WSCC CONSULTATION RESPONSE:

County Planning – Minerals & Waste Planning Authority

TO:	Arun District Council Case Officer: Raymond Cole
DATE:	11 March 2021
LOCATION:	Ford Airfield, Ford
SUBJECT:	F/4/20/OUT: Outline planning application (with all matters reserved except for access) for the development of up to 1,500 dwellings (Use Class C3), 60-bed care home (Use Class C2), up to 9,000 sqm of employment floorspace (Use Classes B1), local centre of up to 2,350 sqm including up to 900 sqm retail / commercial (Use Classes A1-A5) and 1,450 sqm community / leisure floorspace (Use Classes D1-D2), land for a two-form entry primary school (Use Class D1), public open space, allotments, new sports pitches and associated facilities, drainage, parking and associated access, infrastructure, landscape, ancillary and site preparation works, including demolition of existing buildings and part removal of existing runway hardstanding.
RECOMMENDATION:	☒ Advice ☒ Objection ☐ Modification ☐ No Objection ☐ More Information ☐ Refusal

Revised Waste Infrastructure Statement (WIS)

Figure 1: Location of WSCC safeguarded sites

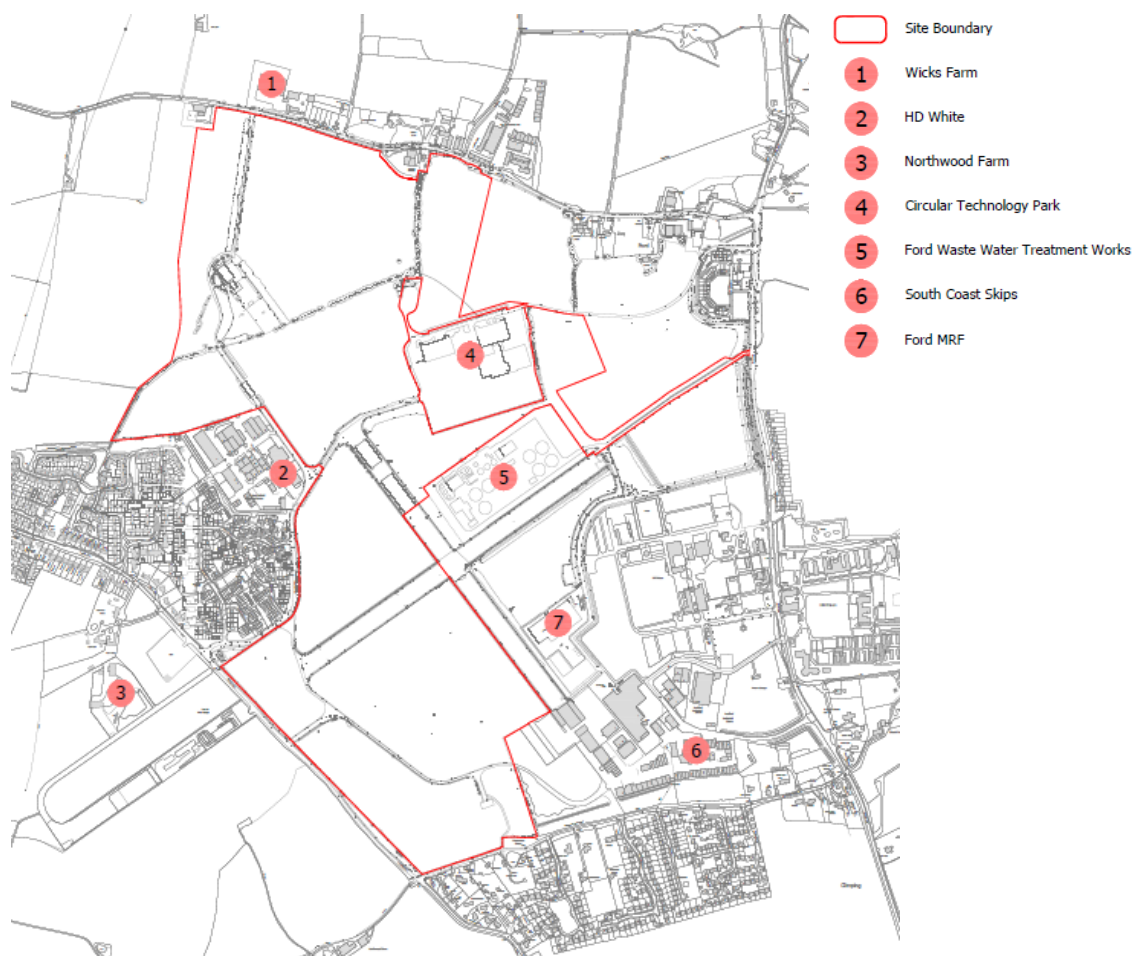
The application site surrounds the WSCC Waste Local Plan (2014) (WLP) Strategic Waste Allocation 'Site north of Wastewater Treatment Works, Ford'. Contrary to the assertions of the WIS that only existing or consented (extant) schemes need to be considered, WLP Policy W10 (d) is clear that the site is safeguarded from any development that would prevent or prejudice its development (in whole or part) for allocated waste management uses. This strategic site has yet to be developed in full as an EfW facility (in accordance with WSCC/096/13), which excludes large areas of the allocation site (Hangars), and where future waste uses are still promoted. Further, the land is the subject of a current planning application for the development of a major Waste Sorting and Treatment Facility (WSTF) and Energy Recovery Facility (ERF) - Ref: WSCC/036/20.

The LPA must give due consideration to both existing and potential future waste development proposals and potential interactions with the proposed development, to ensure any future use of the allocated site would not be unduly prejudiced.

In terms of the noise relationship with HD White Metal Recycling (WSCC/012/12/F), the WIS seemingly concludes that, with attenuation and mitigation, a rating level of 10dB and 4dB above background can be expected at the proposed residential development and care home respectively. It considers that the context of the site is such that receptors would be more tolerant of industrial noise, and that noise reductions from outside to inside would result in recommended daytime levels in habitable rooms. However, Condition 7 of

WSSC/012/12/F requires that the noise rating level from the waste facility at the nearest sensitive residential premises does not exceed 5dB above background. On that basis, the applicant's own assessment shows this pre-existing condition (and thus the existing waste use) would not be operable. Accordingly, the proposed development would prejudice the use of the existing waste management site contrary to WLP Policy W2.

Similarly, in terms of the noise relationship with the extant, part implemented, Grundon waste facility (WSSC/096/13/F), the WIS concludes that several residential premises would experience noise levels in the order of 35-39dBA. Condition 28 of WSSC/096/13/F requires that the noise the rating level from the waste facility at the boundary of the nearest sensitive residential premises (not habitable rooms) does not exceed 35dBA at any time. It is unclear if the this calculated rating level includes consideration or any mitigation proposed, which should also be clarified. The applicant's own assessment shows that this pre-existing condition (and thus the existing waste use) would not be operable. Accordingly, the proposed development would prejudice the use of the existing waste management site contrary to WLP Policy W2.

Figure 4: Typical illustrative plan showing noise mitigation principles, subject to detailed noise assessment and layout planning at reserved matters stage. Not for approval of detailed block layout or type/mix of housing.

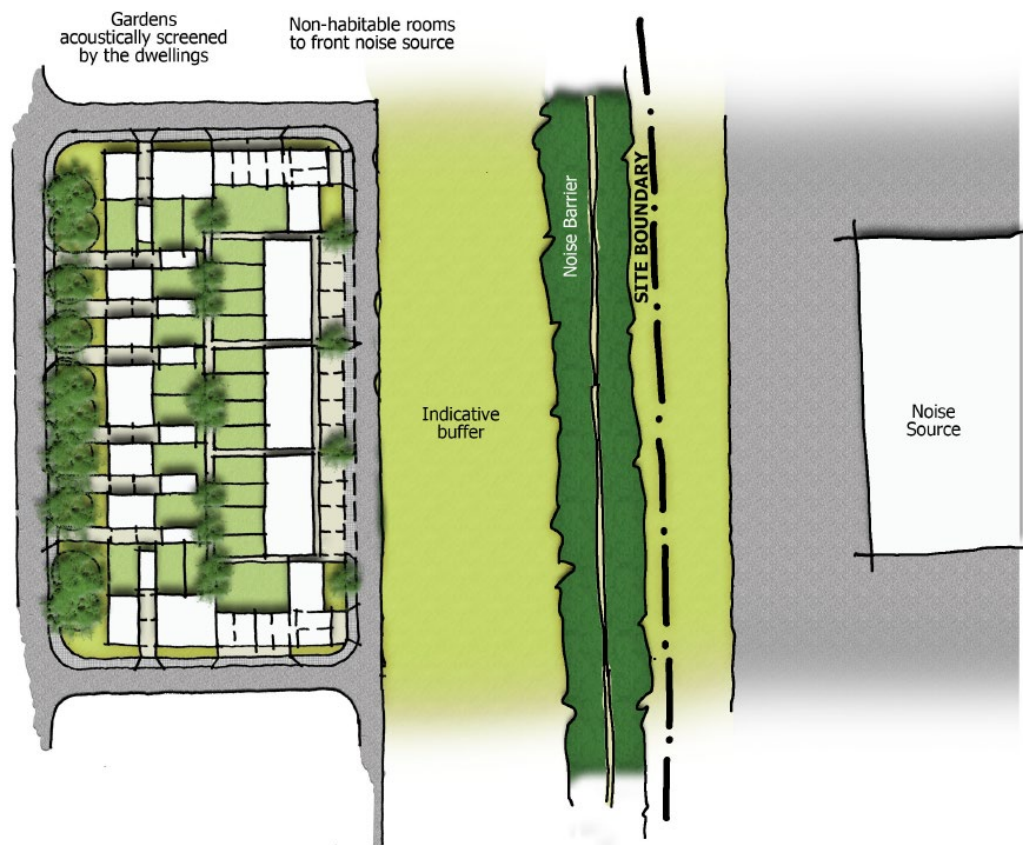
Notwithstanding the above, Section 4 of the WIS includes outline proposals for noise mitigation, which confirm likely need for specific noise mitigation measures to ensure compatibility with three existing waste management facilities, those being; the part implemented Grundon Waste Management Facility at the New Circular Technology Park; HD White Metal Recycling at Ford Industrial Estate; and Viridor's Material Recycling Facility (MRF) at Ford Airfield. In summary, the outline measures include a requirement for a 3m high acoustic barrier around the Ford Industrial Estate, and for areas highlighted in Figure 3 that gardens and habitable rooms be orientated to avoid facing the waste facilities. The applicant proposes that such measures could be secured by condition.

Whilst the proposed mitigation is welcomed, the extent of sensitive receptors that need to be subject to such requirements is cause for concern. Although indicative illustrations seek to demonstrate how such orientations could be achieved, given the extent of areas affected, and types of development proposed (e.g. care homes, primary school, high density residential areas), concerns are raised as to the practicality of such orientations being achievable without significant impact on the layout and deliverability of the scheme. The LPA will need to be satisfied in this regard.

Considering the above, it is also questionable whether the applicant's proposed condition would be sufficiently precise (particularly if mitigation were to be delivered in phases), and/or appropriate. Further, for the avoidance of doubt, the County Planning Authority would wish for any outline masterplan (and/or and Land Use Plans) to be based on required buffers and to detail both specific noise mitigation features (e.g. barriers) and highlight any areas requiring controlled orientation for noise mitigation.
